Arun District Council  
Arun Civic Centre  
Maltravers Road  
Littlehampton  
West Sussex BN17 5LF  
Planning & Building Control General Enquiries  
Tel: (01903) 737756 Fax: (01903) 730442  
Dx: 57406 Littlehampton  
Minicom: 01903 732765  
e-mail: [planning@arun.gov.uk](mailto:planning@arun.gov.uk)  
website: [www.arun.gov.uk/planning](http://www.arun.gov.uk/planning)

Application No: CM/70/21/PL  
Site Address: Land at Wren Cottage Horsemere Green Lane Climping BN17 5QZ  
Description of works: Subdivision of the plot and construction of 3 detached bungalows with associated parking, access and landscaping (resubmission of CM/17/21/PL). This application is in CIL Zone 3 and is CIL Liable as new dwellings.

Thank you for your internet representation made on 13th December 2021 which has been recorded as an objection with the comments as follows:

Title
Location & Block Plan

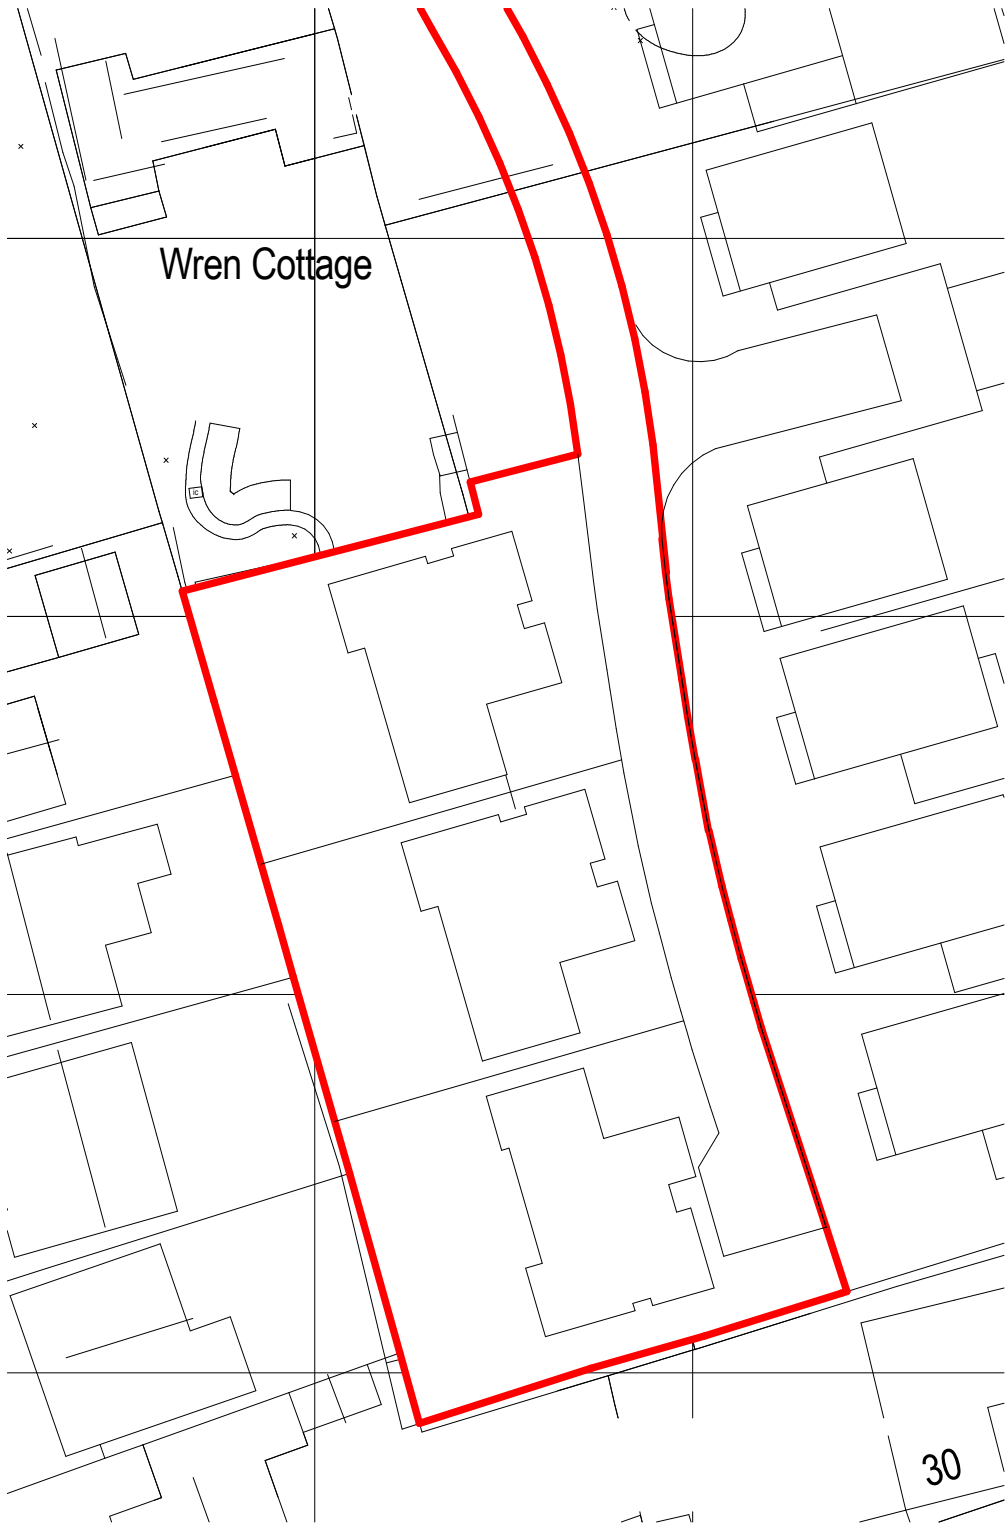
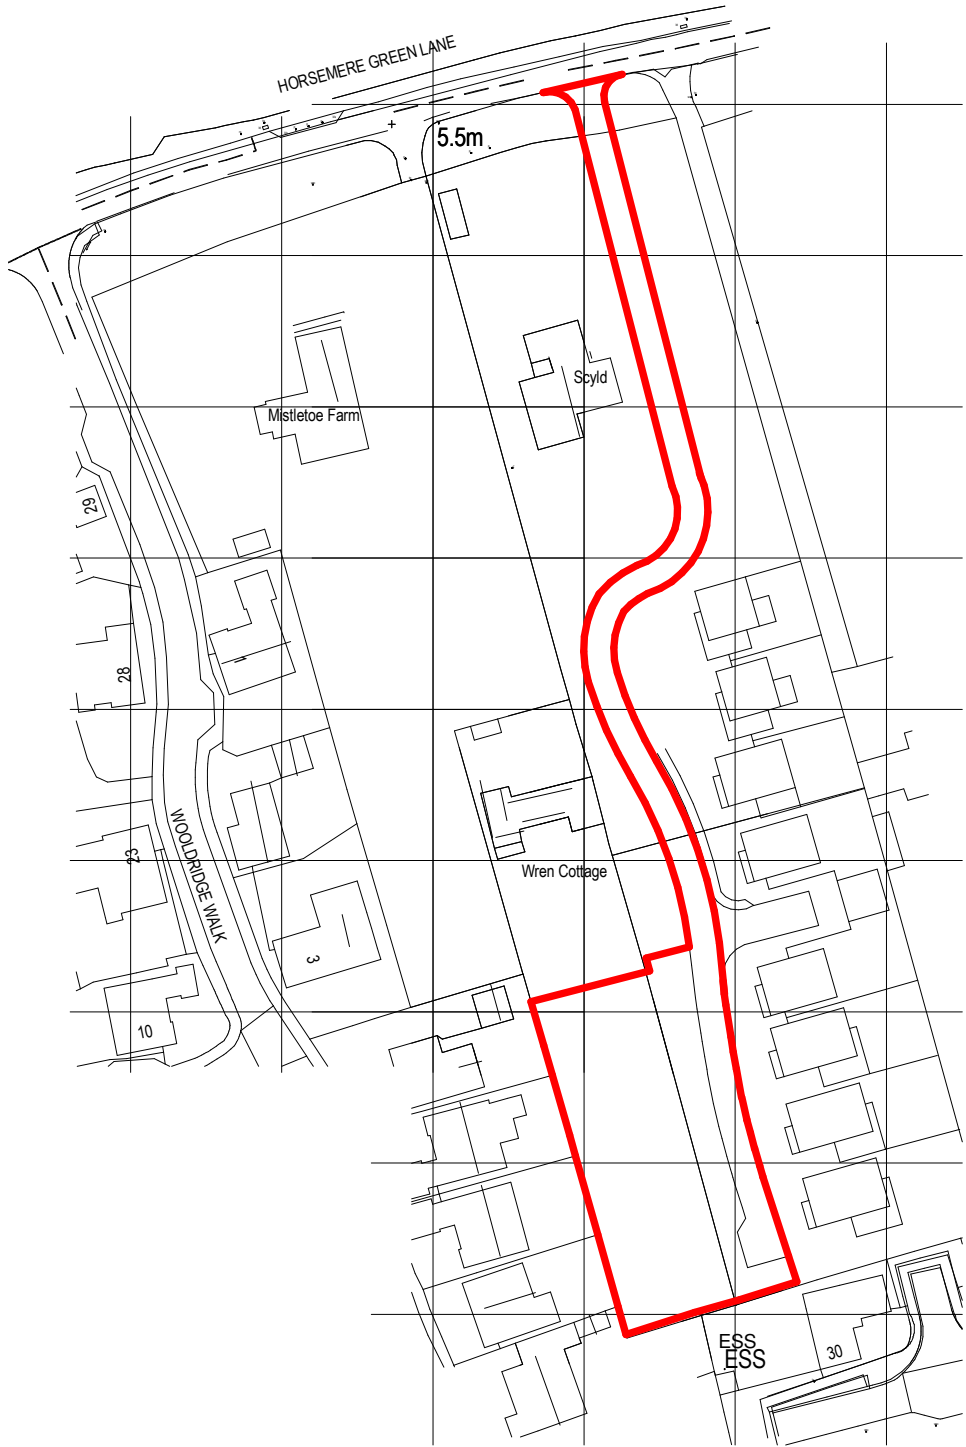
Having perused the resubmitted plans for wren Cottage , our objections are as follows:  
Plot no 3 is still too close to our property as spelt out in the previous refusal, the plans are showing a garden of 10.653 metres but in reality it is only approx 8 metres, the reason being the measurements on the official land registry when we purchased our property to the boundary line as confirmed as being 10 metres, the fact that we have an in-garden fence which was erected in front of our conifers was purely for aesthetics and ease of maintenance .So their measurements do not show a true boundary perimeter which we will be confirming with Lizard Landscape Design to clarify where they obtained their measurements, and the fact that the conifers were planted within our boundary by the previous owner of this property and are nothing to do with Wren Cottage. By looking at photo no 4 on the Lizard Landscape report you will see it shows a definite boundary fence with the conifers on the Wooldridge Walk side of the fence, unfortunately over time the fence has been removed and this is obviously where the confusion lies. To round off this objection surely anyone can see the garden of plot no 3 is too small for what is being proposed .
